Letter of Intent

Application for Approval of Revised Variance of Use ~~and Site Development Plan~~

Gateway Trucking

VA256

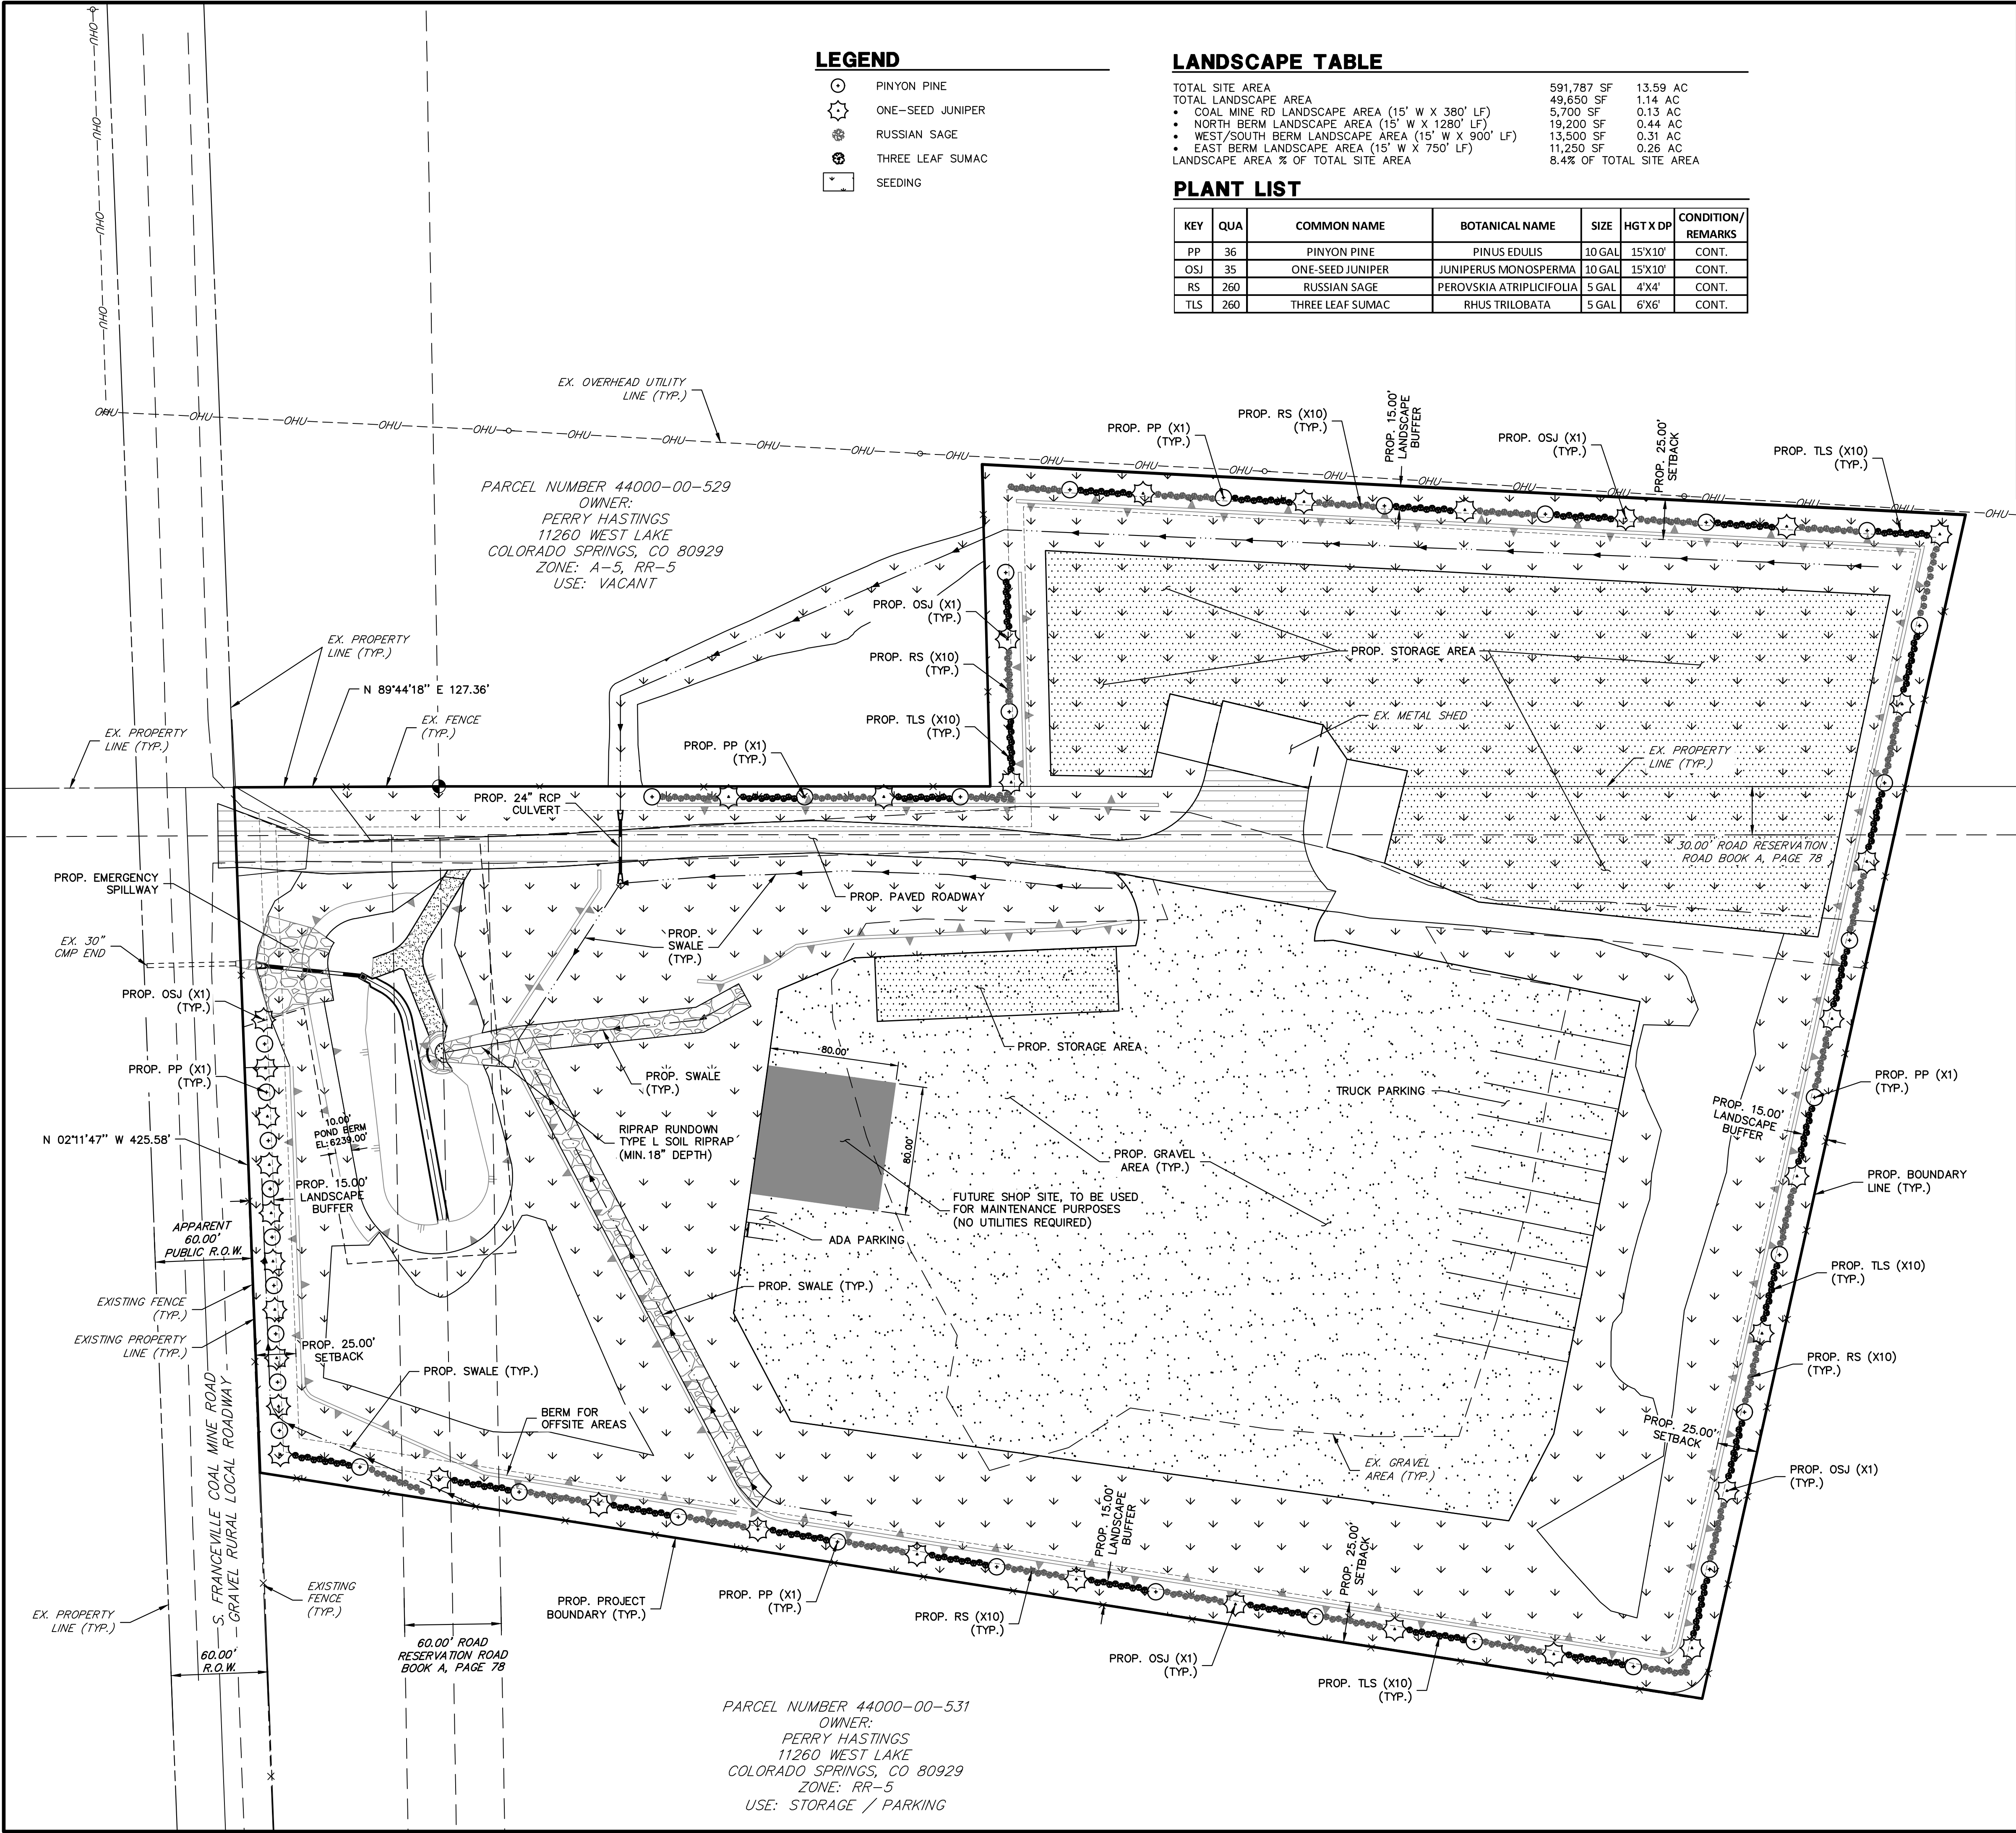
3. From page 3. There is a significant amount of "storage" identified on the site plan. Please. **JR Response: Addressed**

6. This needs to be updated to include the proposed building/shop. Further explanation needed.

9. There is a significant amount of parking on site. Any "Parkin... the Code. See note #2. If an alternative parking ratio is reques... 6.2.5 of... address why the BOCC should allow that as part of the Variance of Use...

4. From page 3. Please note that the Variance of Use request would benefit the applicant more if we allow truck/trailer parking and storage based on area and not limit it to the number of vehicles. The BOCC may put a condition of approval that limits the number of vehicles, but I think it would be reasonable at this time to simply request parking and storage areas. For example, label and count all parking spaces on the site plan. Label and provide sq ft for all designated storage areas. **JR Response: Noted, requested parking and storage areas as requested.**

JR Response: Added the shop

JR Response: Addressed. Revised the parking as directed and proposed alternative parking ratio.

GATEWAY TRUCKING SITE DEVELOPMENT PLAN LANDSCAPE PLAN
DESIGNED BY: GAG
DRAWN BY: GAG
CHECKED BY:
SHEET 1 OF 1
JOB NO. 25215.00

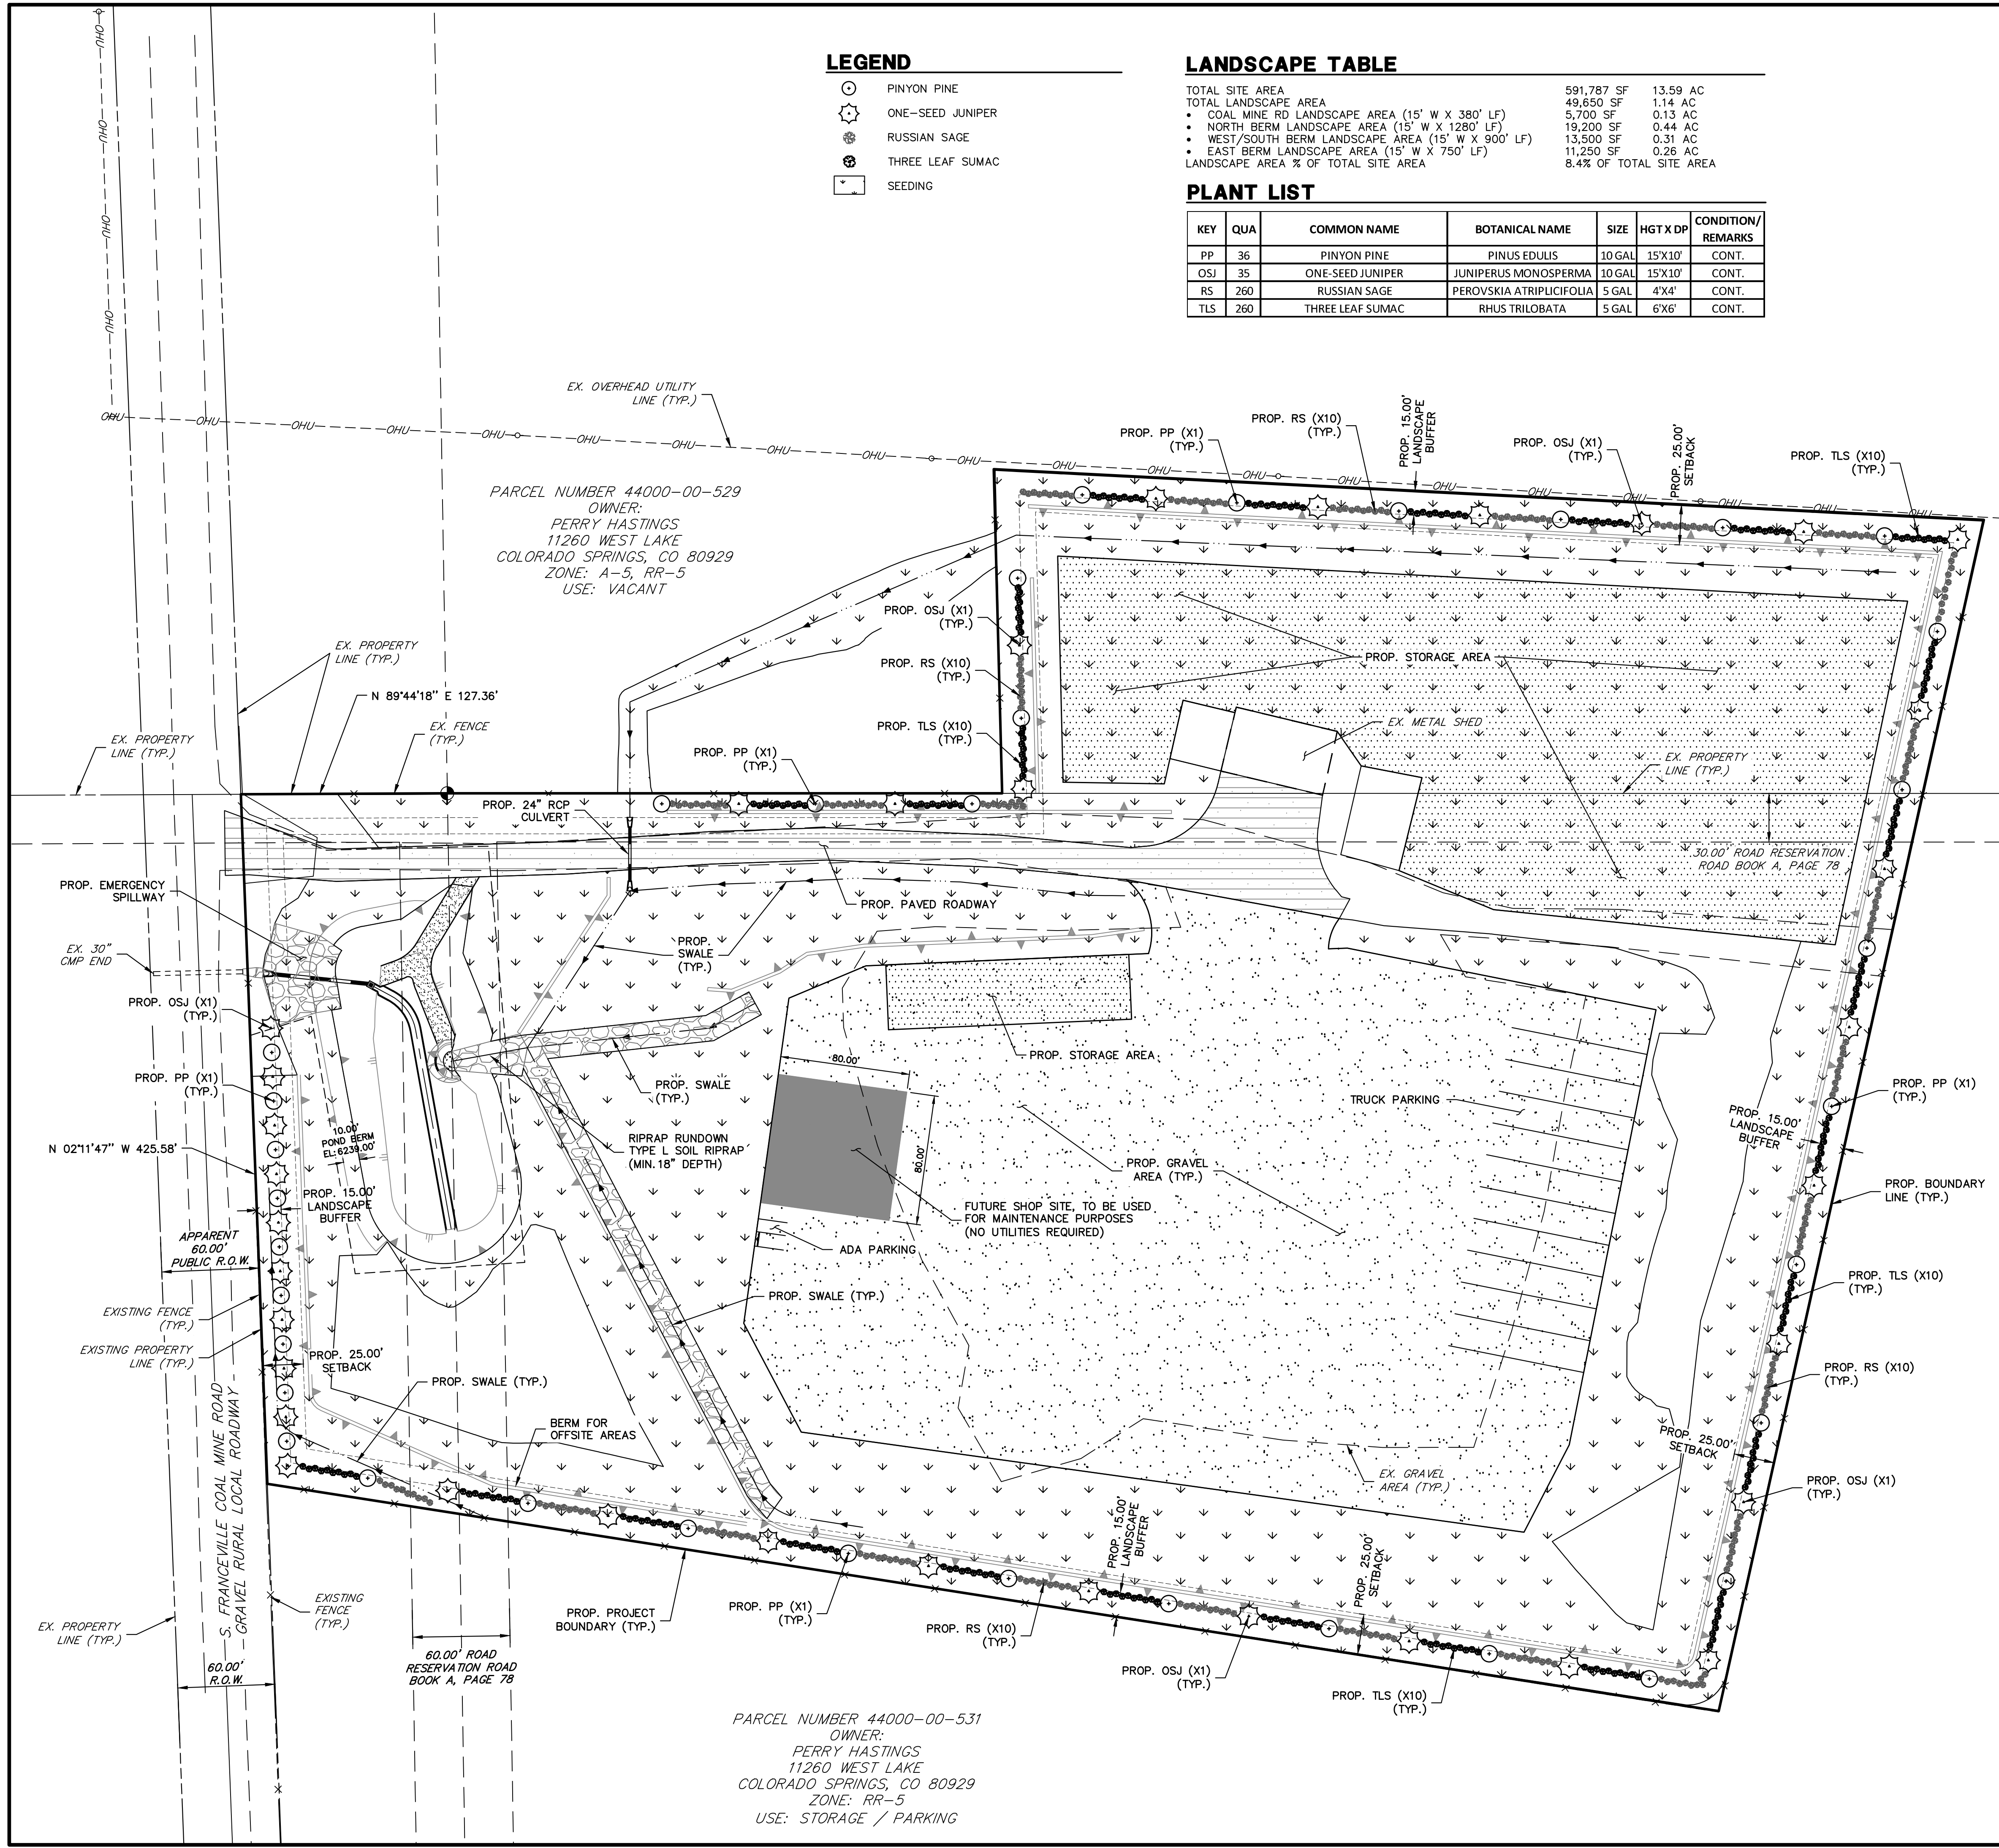
and other agricultural activities and provide a natural buffer to adjacent properties. The LDC Section 6.2.2(D) Required Buffer and Screen Areas, requires a 15 foot deep buffer and 1 tree for every 25 feet. The Applicant proposes alternative landscaping design to provide 1 tree every 50 feet in the buffer area with a minimum of 10 shrubs between trees (i.e. 1/2 of required trees be replaced by 10 shrubs each). This will reduce the amount of water needed to maintain the landscaping.

4. Internal Landscaping: The LDC Section 6.2.2(E) Internal Landscaping requires that a minimum of 5% of the lot or parcel be landscaped and 1 tree for every 500 square feet of landscape area and that 1 tree shall be required for every 500 square feet of required internal landscaped area and that a maximum of 1/2 of the required trees may be substituted with shrubs. This requirement is met by the trees and shrubs in landscape buffer as well as existing native grasses and vegetation on the property, as shown on the landscaping plan.
